WEST SUSSEX COUNTY COUNCIL CONSULTATION

TO:	Arun District Council FAO: Maria Tomalova
FROM:	WSCC - Highways Authority
DATE:	12 April 2022
LOCATION:	Land East of Eastmere House Eastergate Lane Eastergate PO20 3SJ
SUBJECT:	BN/26/22/PL Construction of 1 No. two storey detached dwelling house on existing paddock. This application is a Departure from the Development Plan and is in CIL Zone 3 and is CIL Liable as new dwelling.
DATE OF SITE VISIT:	n/a
RECOMMENDATION:	More Information
S106 CONTRIBUTION TOTAL:	n/a

Image 4: proposed site plan (n.t.s.)

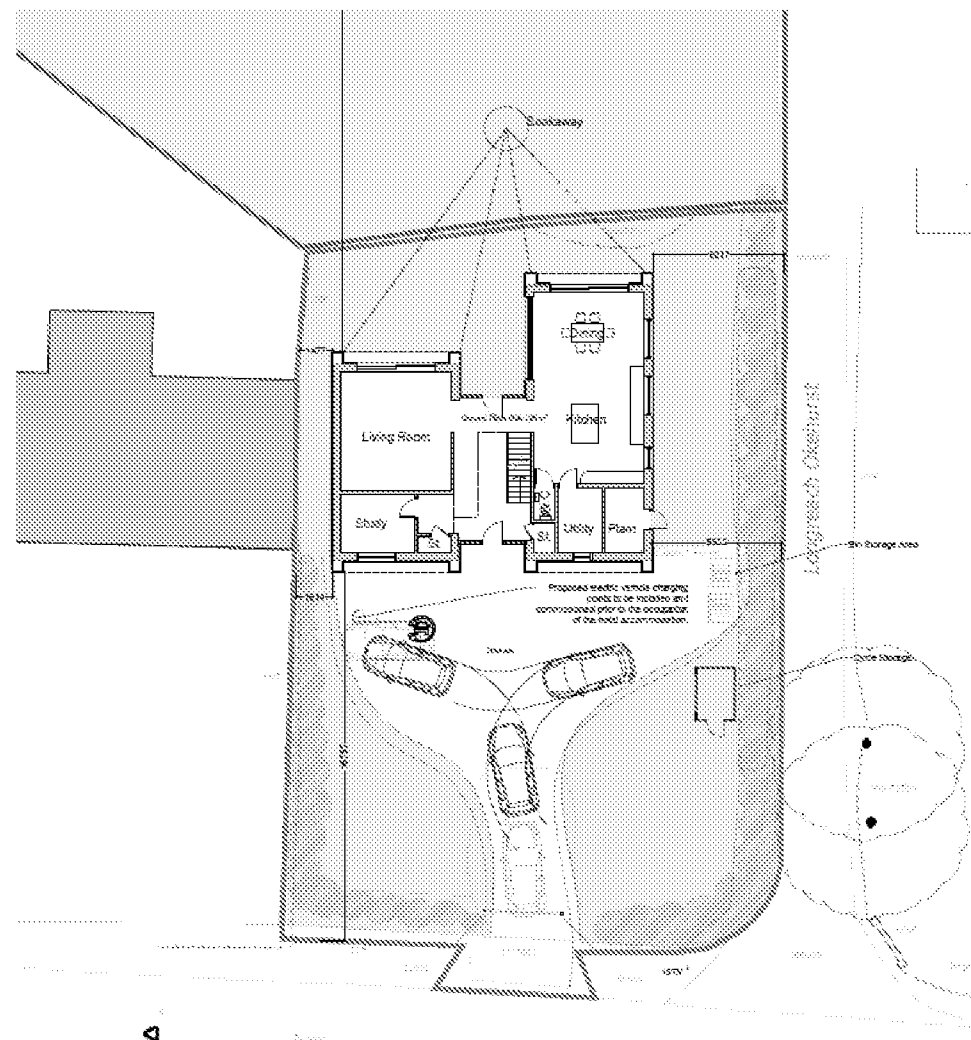
The proposed plans demonstrate that a new 6.3m wide vehicle crossover (VCO) will be provided to serve the proposed dwelling. The access works would be subject to a licence from the WSCC Area Engineer and must be constructed to a specification agreed with them. This would require that the VCO be constructed of a hardbound material - the LHA note that the VCO is currently annotated to remain 'unmade'.

The proposed plans demonstrate visibility splays of 2.4 x 120m in each direction from the centre of the proposed access. Whilst this is accepted to the west of the site, the splay to the east passes through third party land and as such cannot be secured in perpetuity. The applicant is requested to provide splays in accordance with the road speed in this location, utilising only the applicant's own land, or land considered public highway. If a splay of 120m to the east is not achievable in this location, the applicant may wish to conduct a 7-day speed survey to determine 85th percentile speeds in this location, to support reduced splays.
